24 September 2025

SSD-64916225 Western Sydney University Indigenous Centre of Excellence

I refer to the Department's email of 23 September 2025 regarding the Amendment Report for State Significant Development SSD-64916225 Western Sydney University (WSU) Indigenous Centre of Excellence for 'A new four-storey Indigenous Centre of Excellence at the Western Sydney University Parramatta South Campus, comprising arts, education and community spaces, amended to include two new carparks in proximity' at 171 Victoria Road, Parramatta (Lot 100 DP 816829) in the City of Parramatta Council local government area (LGA). Submissions need to be made to the Department by 7 October 2025.

DRAWING NUMBER
DA 1-102

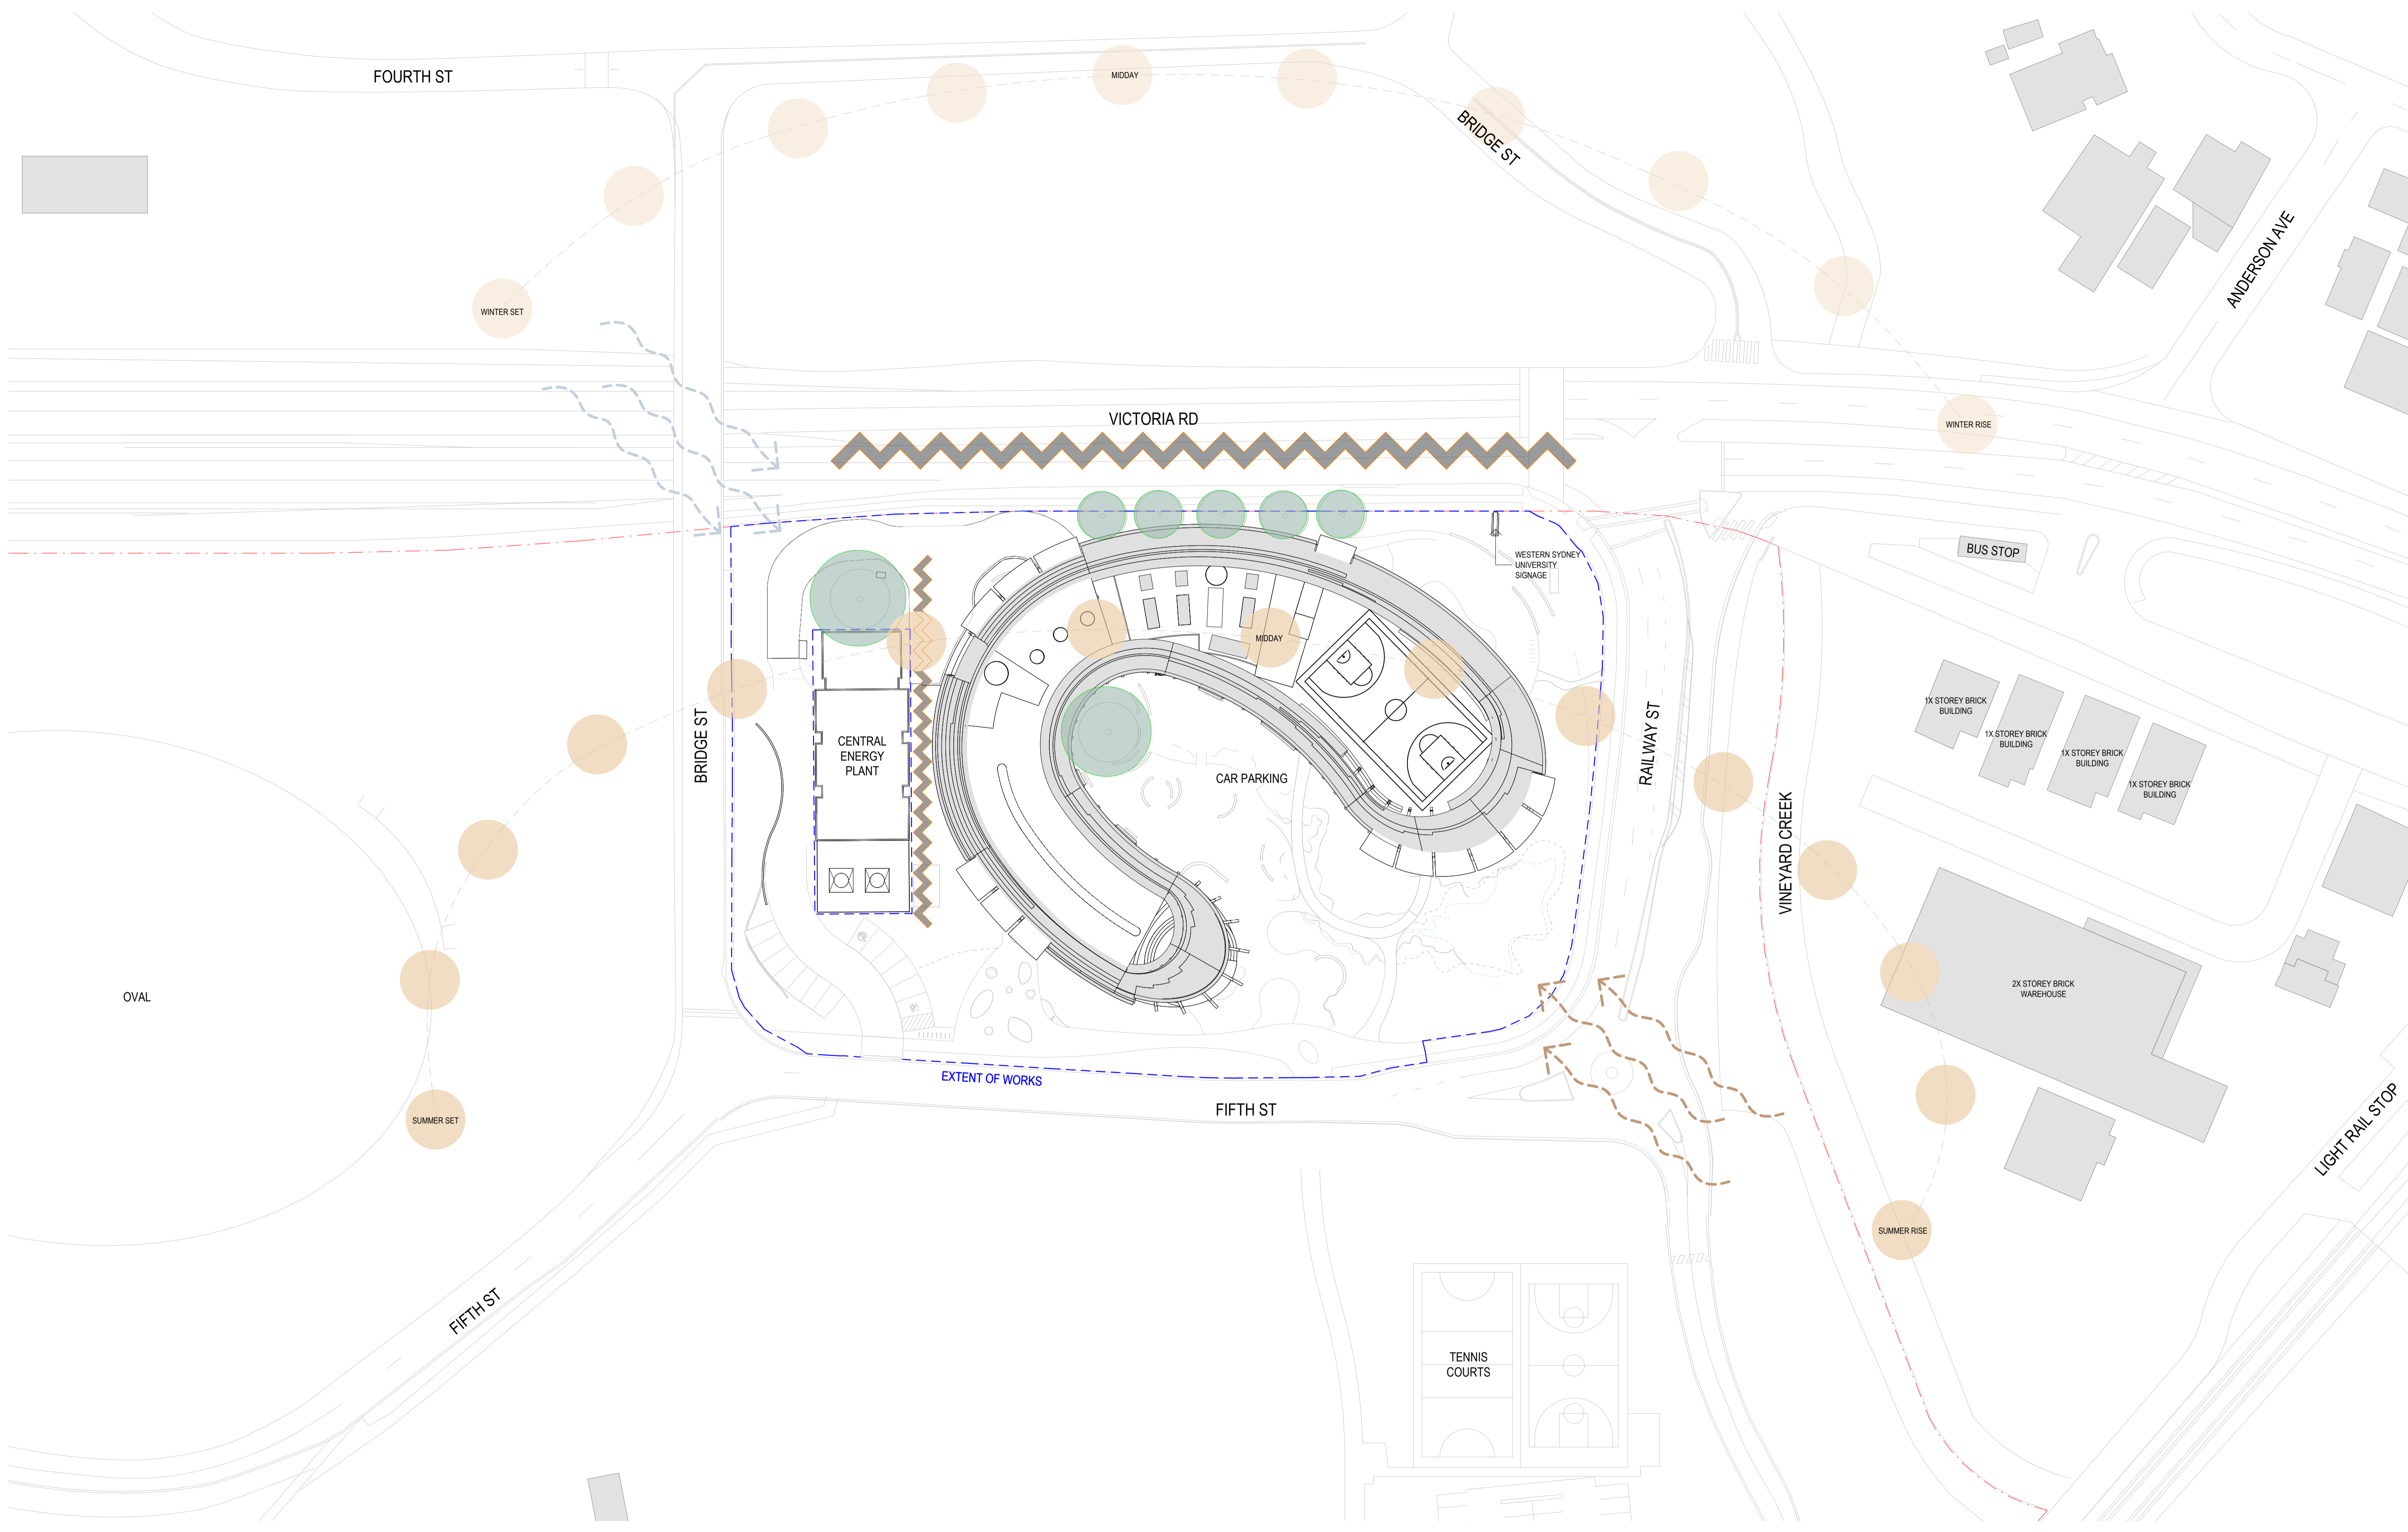
The below copy of the Proposed Floor Plan_Level G shows provision for a 'PAD MOUNT SUB STATION'. Any required padmount substation will need to be located within the property (in a suitable and accessible location) and be protected (including any associated cabling not located within a public road / reserve) with an appropriate form of property tenure as detailed in the attached copy of Endeavour Energy's 'Land Interest Guidelines for Network Connection'.

Generally it is the Level 3 Accredited Service Provider's (ASP) responsibility (engaged by the developer) to make sure substation location and design complies with Endeavour Energy's standards the suitability of access, safety clearances, fire ratings, flooding etc. If the substation does not comply with Endeavour Energy's standards, the applicant must request a dispensation.
